November 7, 2023

Site: 4719 86th Ave SE SP
Mercer Island, WA 98040
TPN: 7598100420
Area: 28,644 sq ft. = .66 acres

Re: RFI dated February 2023 all corrections highlighted in yellow

City Arborist

TREE PLAN
 4719 86TH AVE SE
 MERCER ISLAND
 WASHINGTON 98040
 PARCEL NO. 7598100421

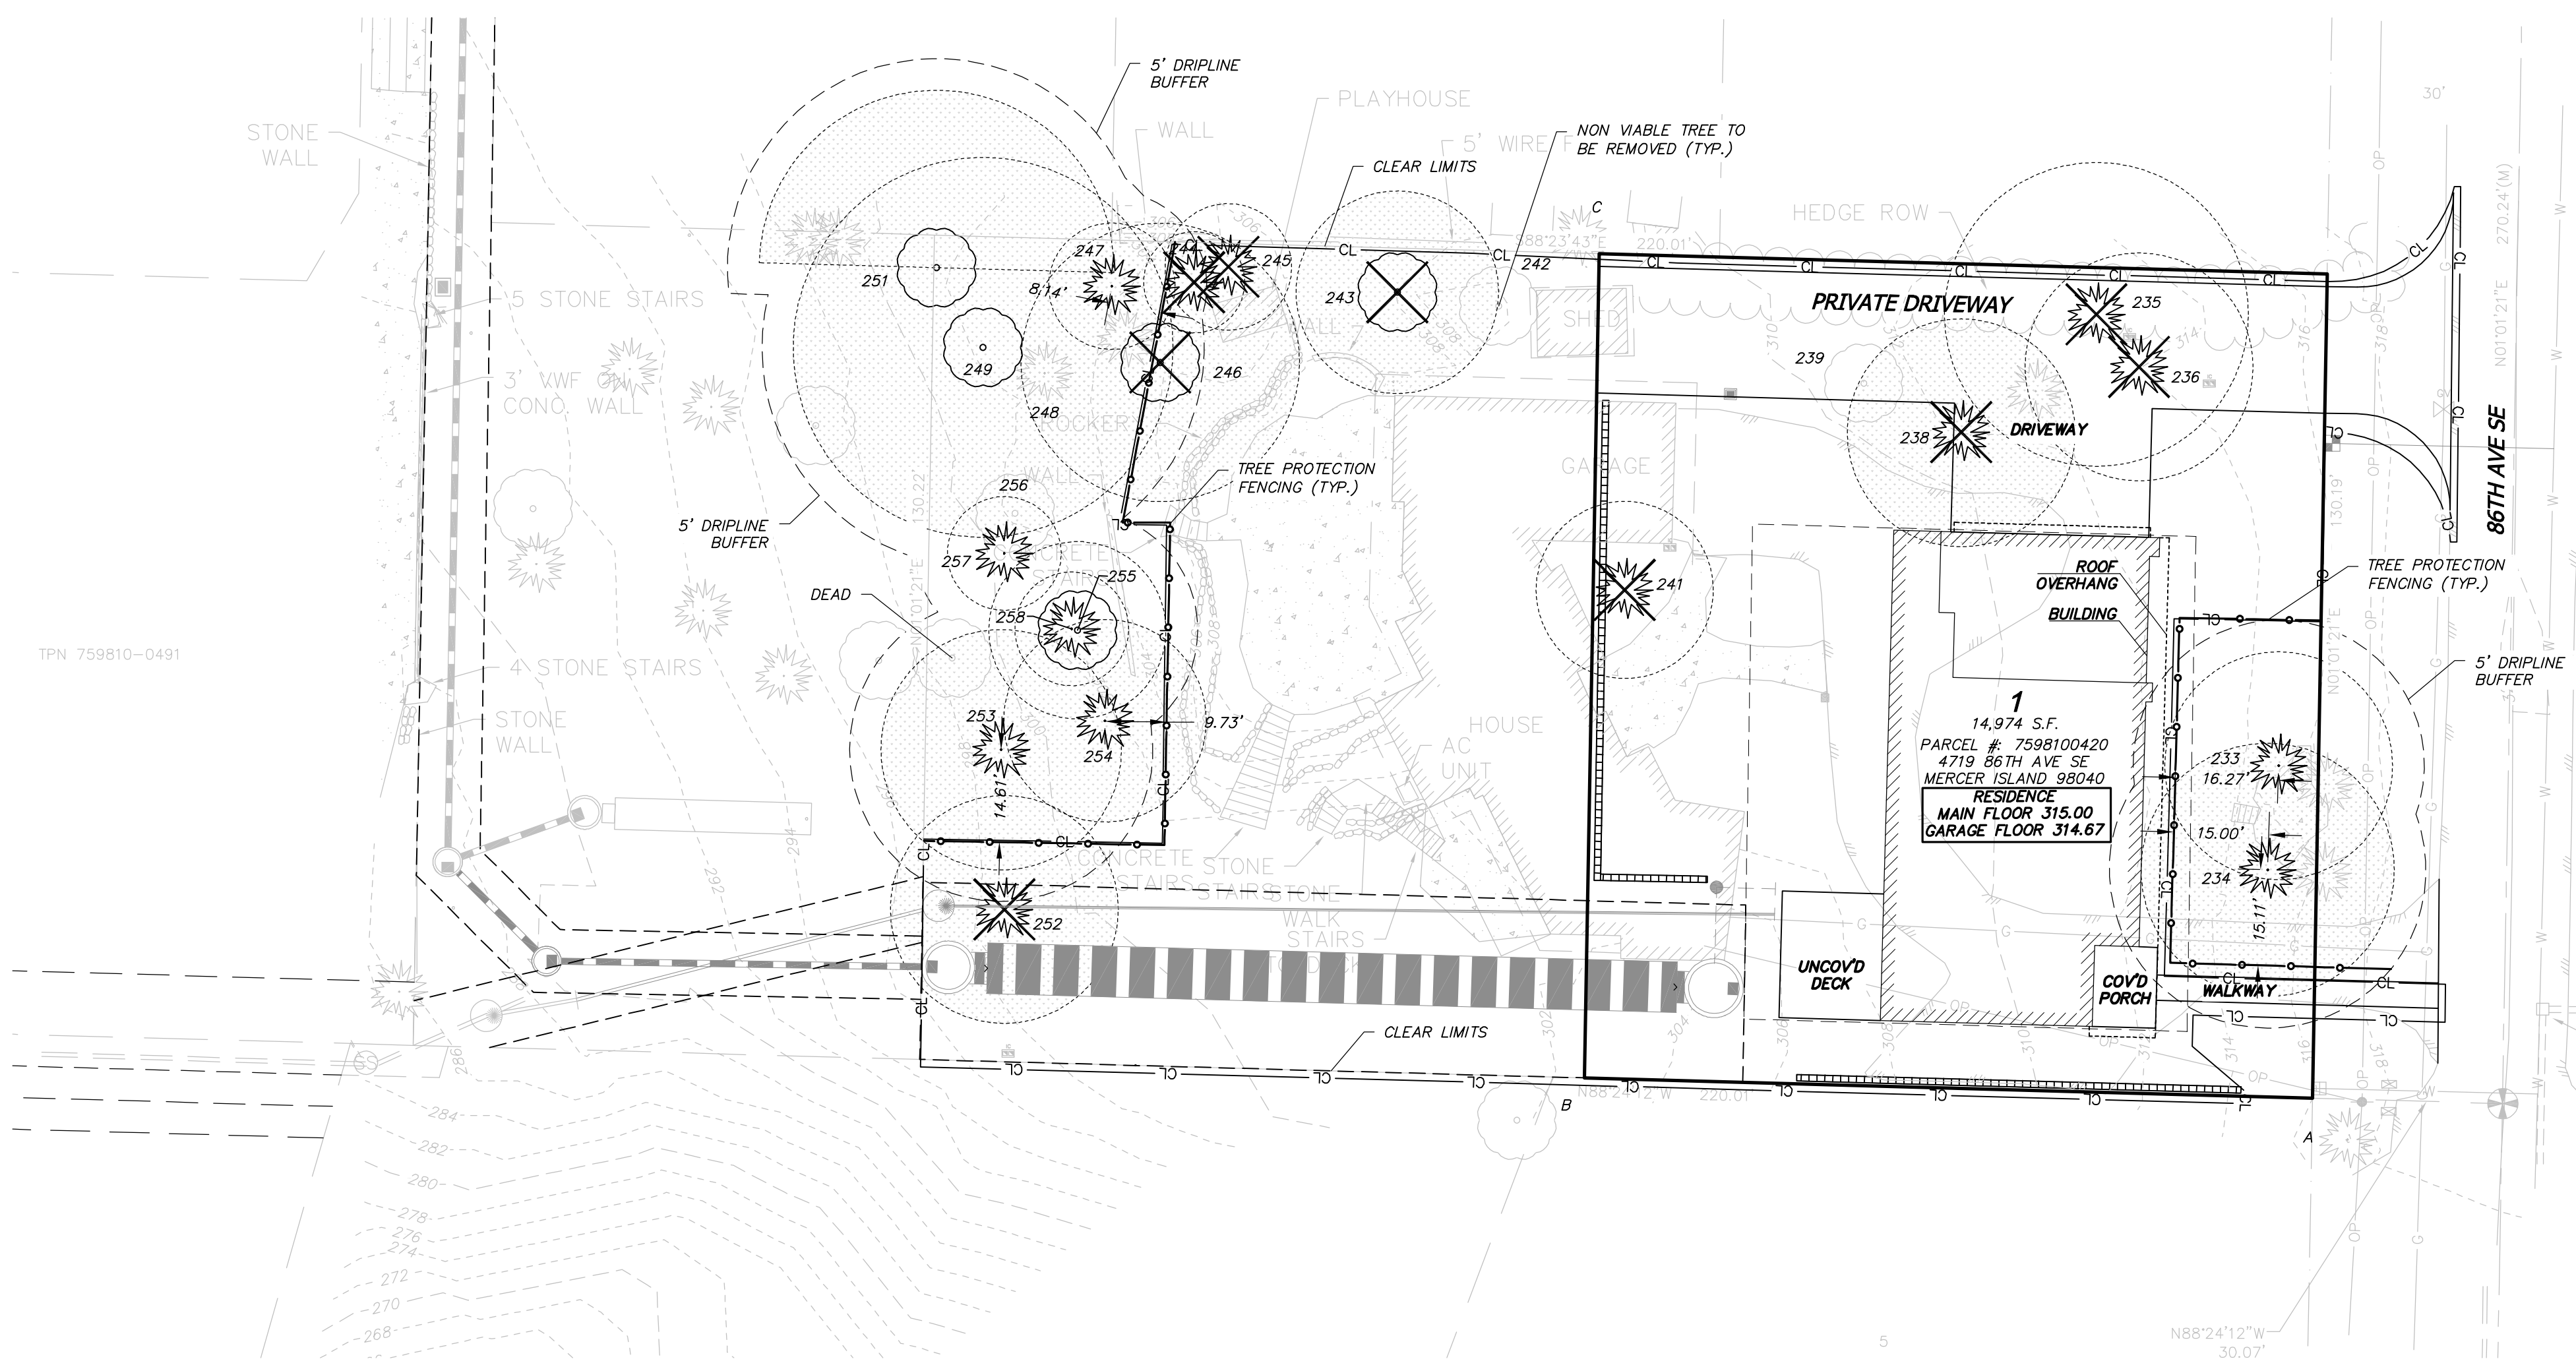
8. Please move the building pad and over excavation outside of the critical root zones of trees 233, 234, 249, and 253. Air excavation root analysis will need to be provided prior to construction to demonstrate that these trees will not be damaged by the proposed work. The analysis will need to call out the specifics of the project design. Alternatively, these trees could be proposed to be removed if the minimum required number of regulated trees will be retained. The building envelope was moved 5' to the west to reduce the potential impact of construction on tree #233 & 234) I have reduced the LOD by a 2' and 5' respectively (see "Onsite Tree Observation Table on pages 7-11). The soil around the roots will be air-evacuated and the exposed roots will be cut cleanly to BMP, ANSI 300 and ISA standards.

9. Please provide a tree replacement plan for at least 49 trees. If you can show that there is not enough space on the lot for the required replacement trees, you may request a fee in lieu that charges \$919 for each tree that cannot be replaced. A bond or assignment of funds will be required at the final plat, which will be completed before building permits for the lots are finalized.

Mitigation was originally 49 trees; however, the applicant has revised the site grading and retained additional trees. Mitigation is now thirty-six (36) trees. The site will only accommodate thirteen (13) replacement trees requiring a fee-in-lieu-of of (23 trees X \$919) \$21,137.
